2 September 2020

Your Ref: SSD-8636-Mod-2
Our Ref: R/2018/7/E
File No: 2020/384579

New Request for Advice – University of Sydney – Engineering & Technology Precinct – SSD 8636 Modification 2

EXTERNAL WORKS -ENGINEERING WALK AWNING - SHEET 2

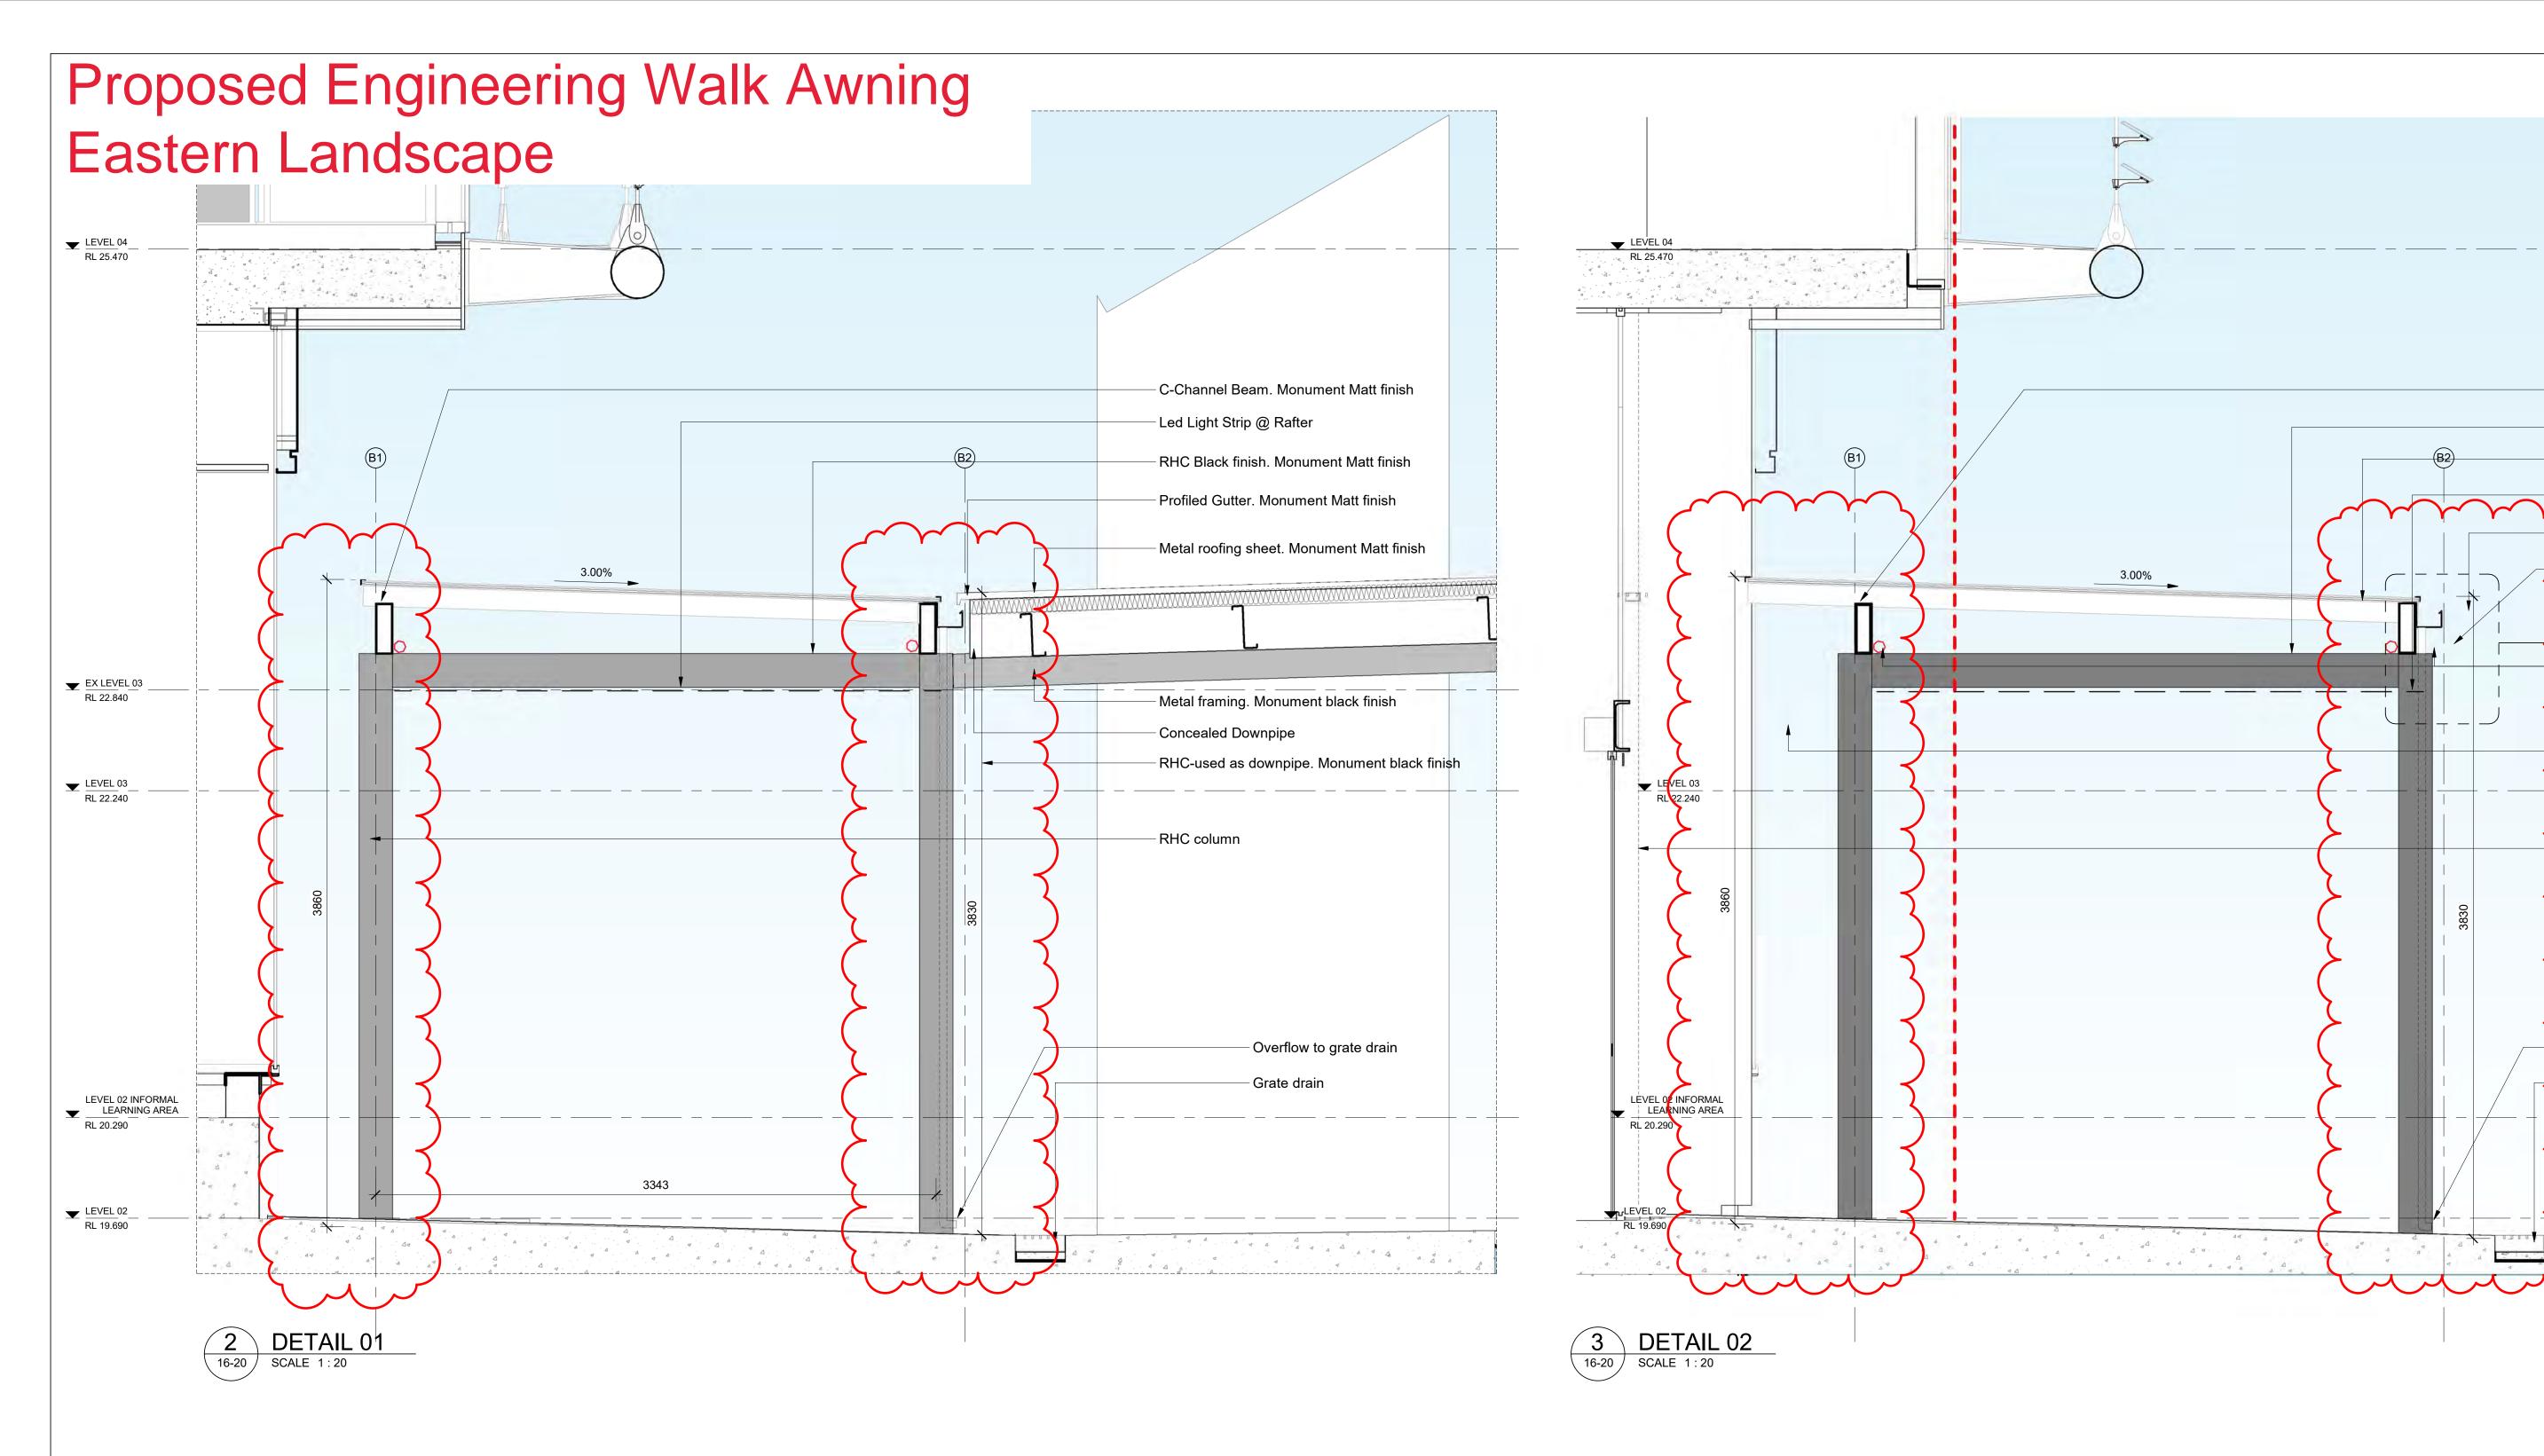
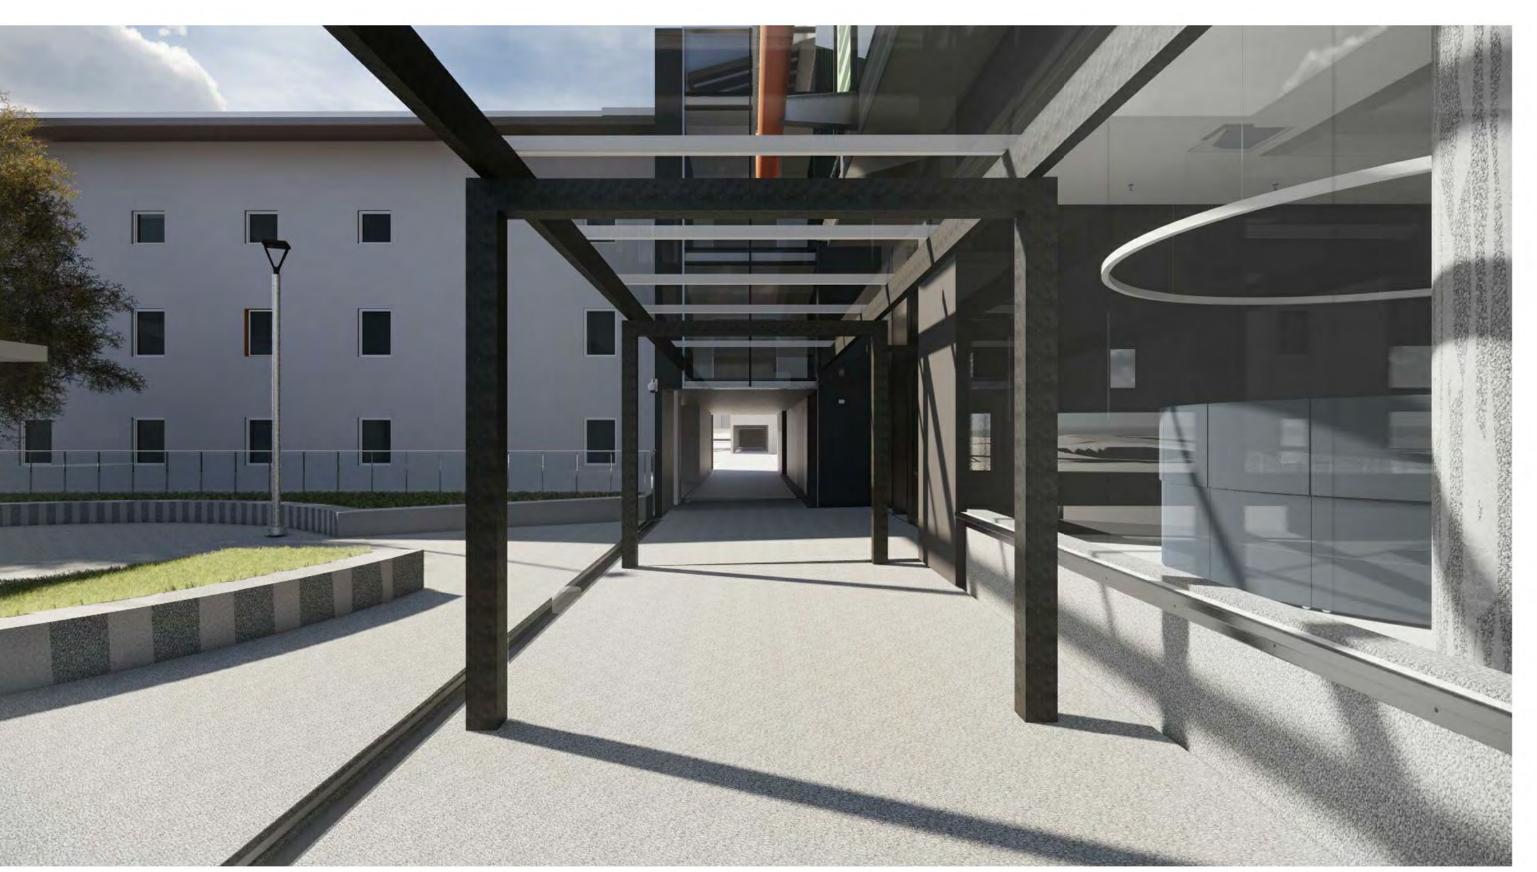
Changes to the East plaza include rationalisation of the layout and addition of a new glazed awning (3.5-4m high) to engineering walk for users accessing the bike racks that segregates the landscape from the building. It's unclear if the seating walls will be accessible for students to sit and learn outdoors or now just a space that's viewed from the building.

Sections 02 Northern Courtyard Details

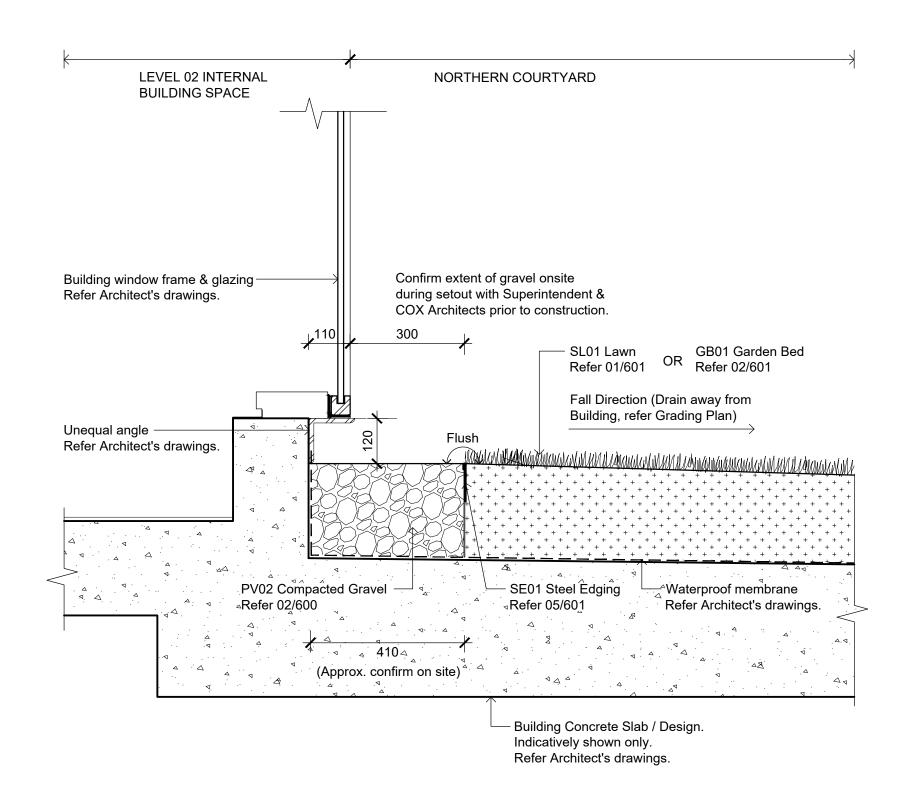
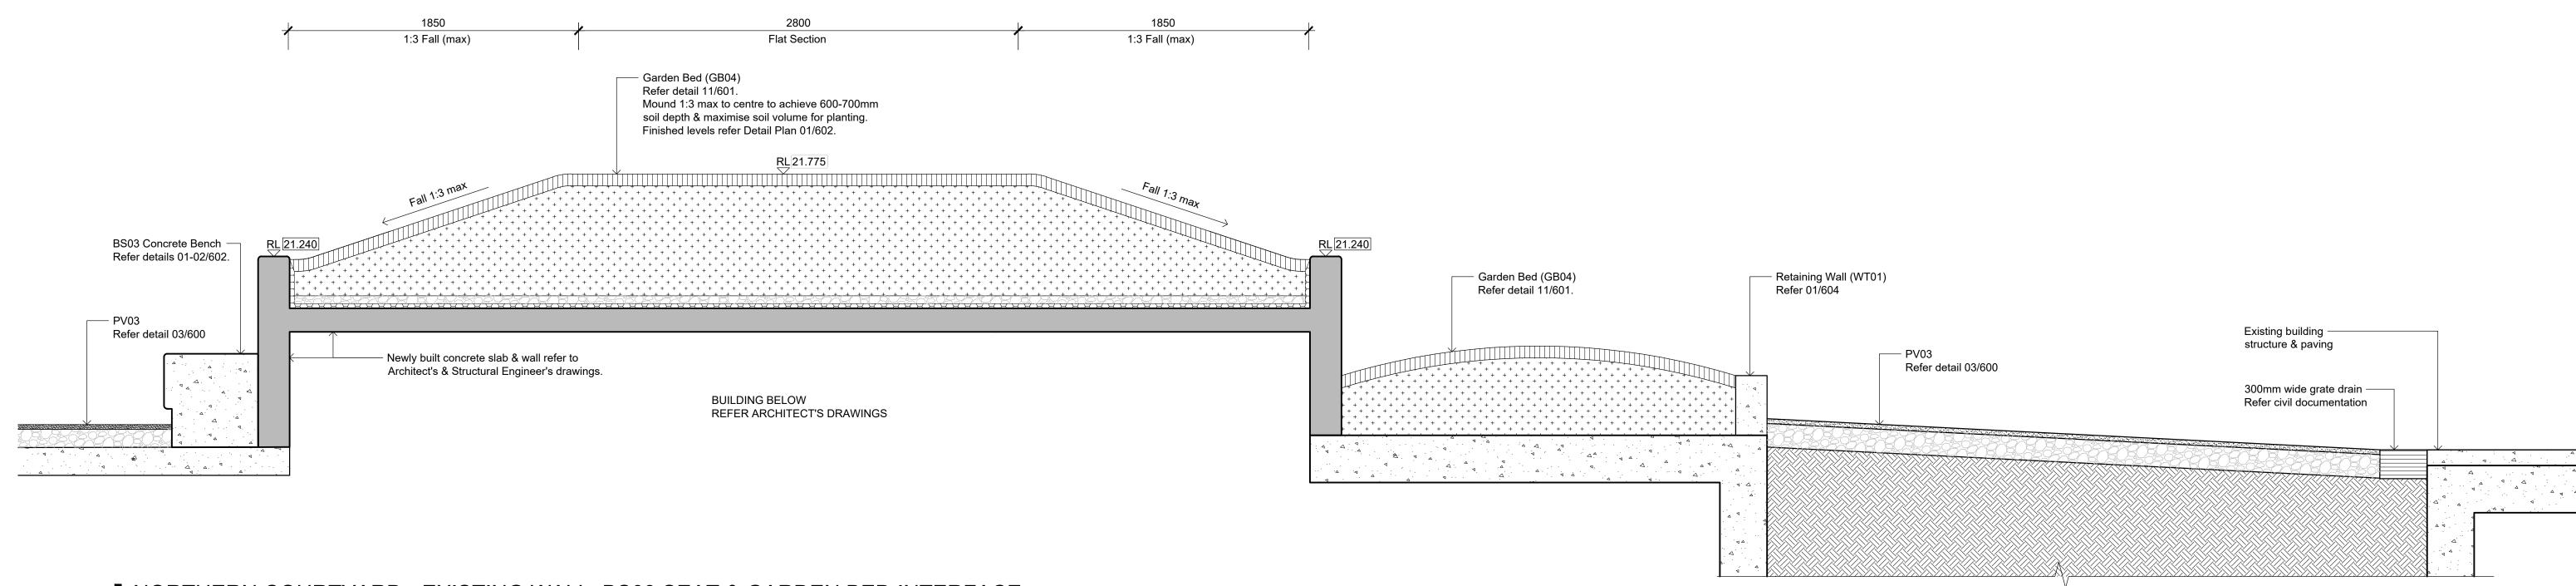
The proposed tree species within the northern landscaped area are predominantly small to medium sized trees that would reach a mature height of 10 metres. The City recommends larger canopy trees with a minimum mature height 15 metres are provided to achieve the 15% canopy coverage in accordance with the Sydney DCP 2012. The proposed raised tree planters on slab will not provide adequate soil depth to support healthy tree growth and do not comply with the Sydney Landscape Code. Consideration must be given to adequate soil availability and space (above and below ground) for all tree species to reach their full genetic potential.
